Ribble Valley Borough Council
Housing & Development Control

Application no: **3/2022/1062**

Address: **Little Town Farm Chipping Road Thornley PR3 2TB**

Proposal: **Proposed agricultural workers dwelling and farm office over detached garage.**

Planning
Proposed Block & Site Plans

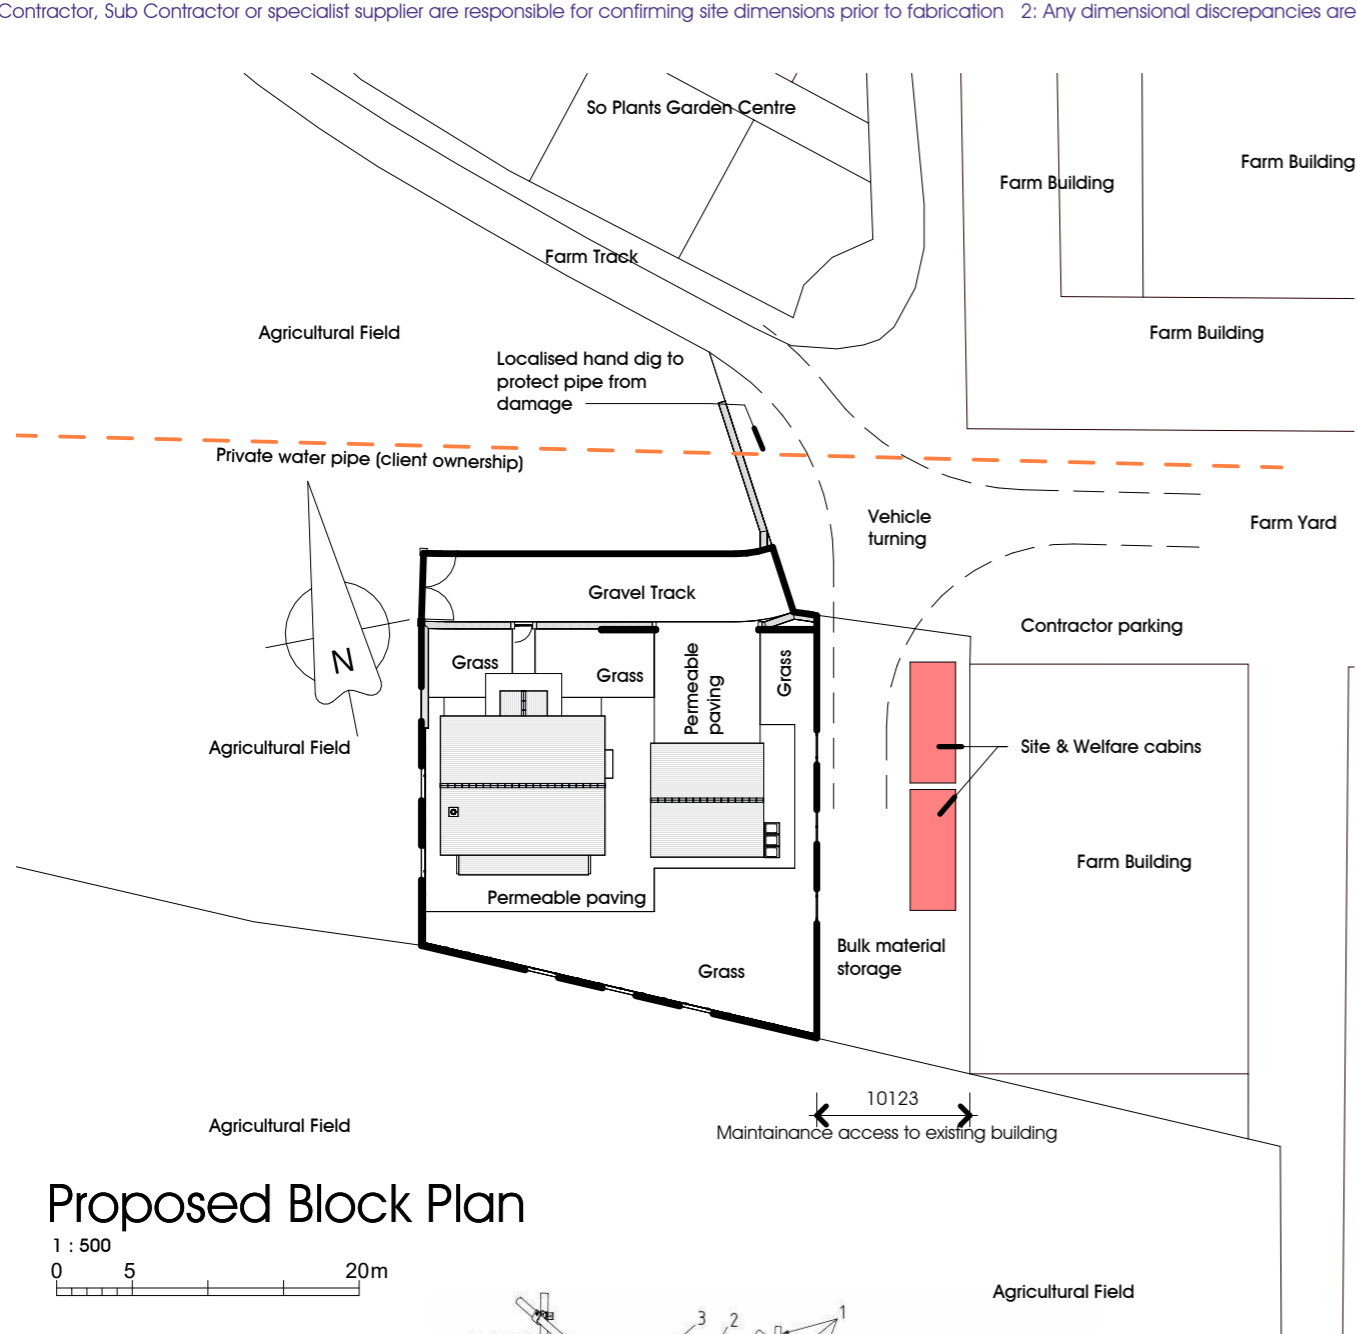
The LHA have reviewed PGB drawing number 003 titled "Proposed Block and Site Plans" and are aware that the 3-bed dwelling will comply with the LHAs parking guidance as defined in the Joint Lancashire Structure Plan.

The LHA will condition however, that a minimum of one electric vehicle charging point should be provided to serve the site. This can be provided either in the proposed double garage or on the driveway.

2. The development hereby permitted shall not be occupied until such time as the parking and turning facilities have been implemented in accordance with PGB drawing number 003. Thereafter the onsite parking provision shall be so maintained in perpetuity.

3. The detached garage shall include provision for an electrical supply suitable for charging an electric vehicle.
